Comments on the Applicant's Responses to Deadline 4 Submissions [part 11 – Response to Mr Moore and Dr Moore]

Unique Reference Number: 20040614

In their Section 2, which actually does relate to me, Tritax have responded to my document "Response to the Examining Authority's Written Questions and Request for Information ExQ1 Question 1.8.18 regarding the Applicant's methodology for noise assessment in the proposed Hinckley National Rail freight Interchange." of the 9th January 2024 (Deadline 4).

00:00 on 28/04/2021 to 00:00 on 29/04/2021

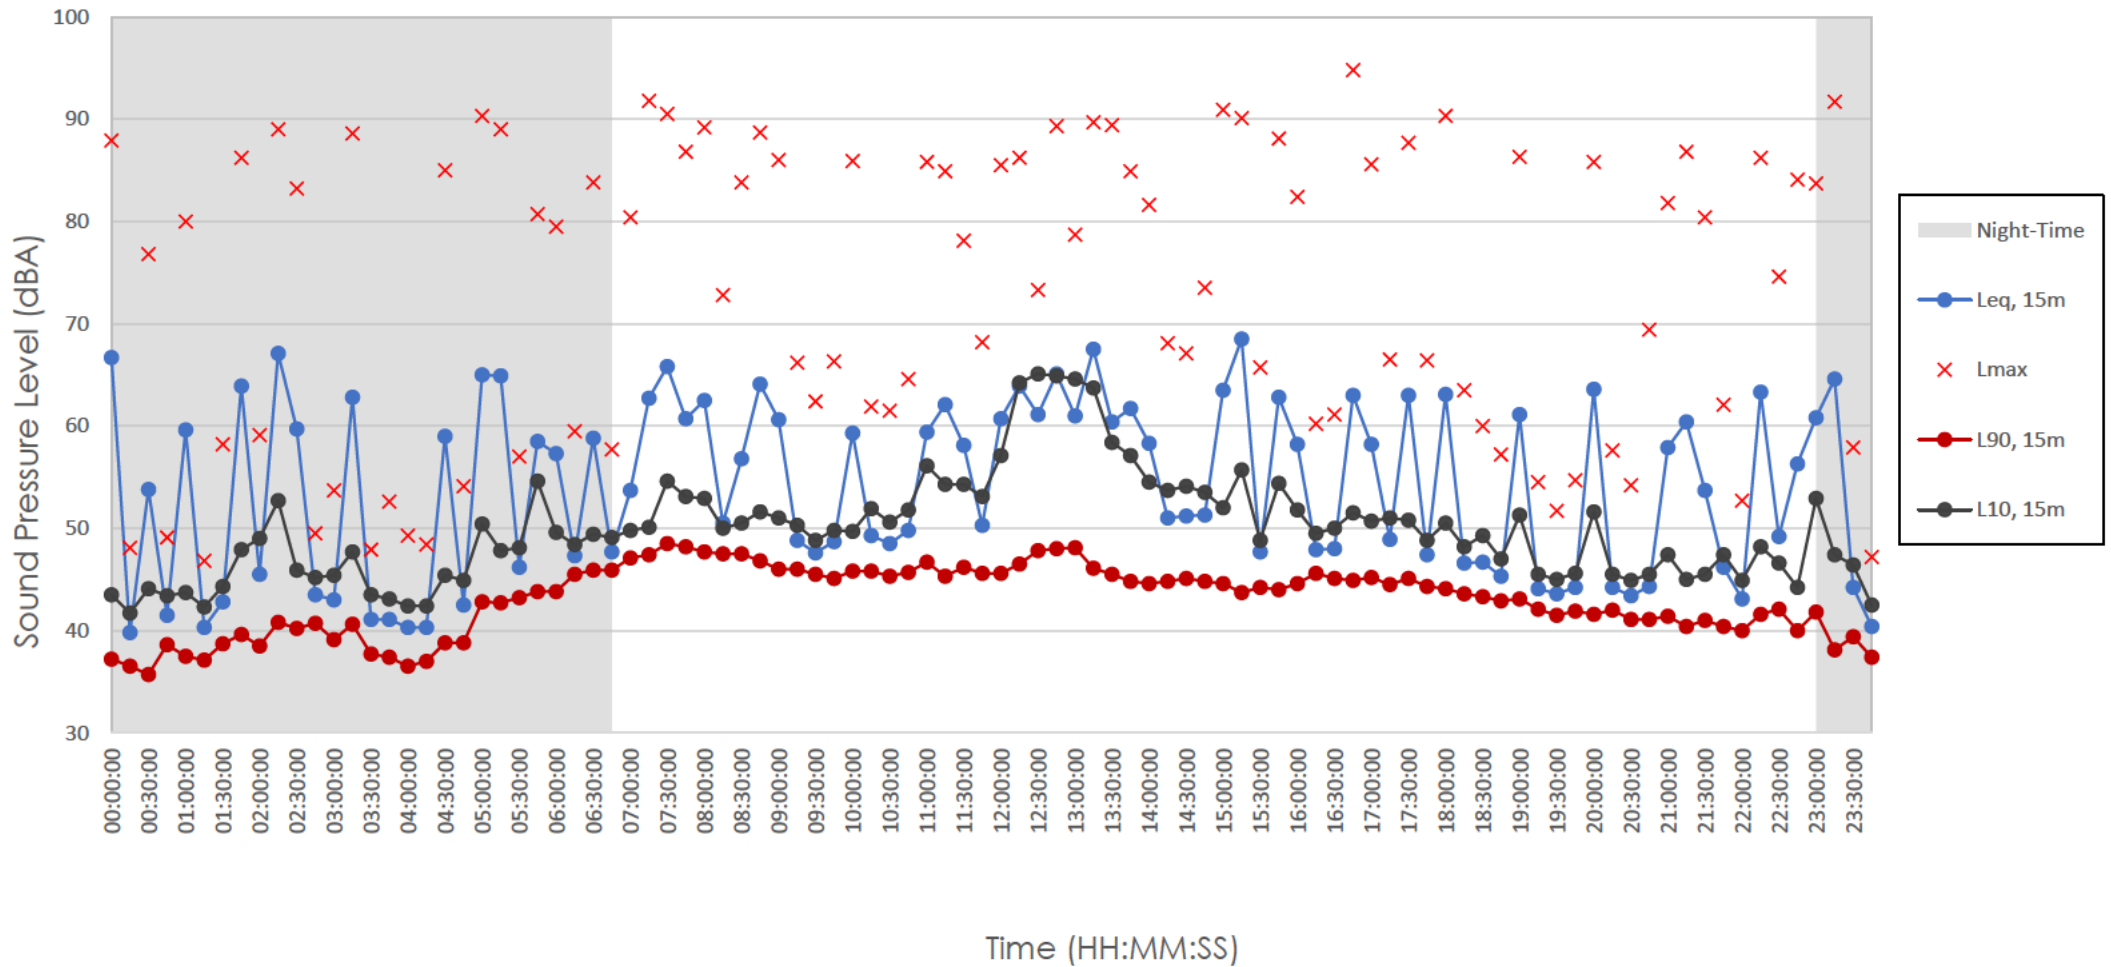
Moreover, the noise levels Tritax measured at the trackside and indicated in graphical form in Tritax’s ES Appendix 10.10 “Summary Results” are entirely in line with the train passby characteristics that I have indicated.

Tritax’s statement is incorrect, as I shall explain. The noise levels measured at the trackside over the 7-day period are continuous along the length of the line that is considered here, **and no rail noise maps are required**. Further, the DEFRA rail noise maps that Tritax have sought to introduce are intended for use only at a strategic level and are very much higher (12dB to 15dB) than the noise levels that Tritax measured at the trackside at NMP3 and NMP4 over the 7-day period and then used as a foundation of their Noise and vibration report.

Moreover, the DEFRA rail noise maps give no indication of the noise levels at Weekend daytimes or Weekend night-times, and indeed are so broad-brush that they indicate a **higher** rail noise level at night-time than daytime. In contrast, the noise levels Tritax measured at the trackside over the 7-day period give detailed information for both Weekends and Weekdays, and both daytime and night-time.
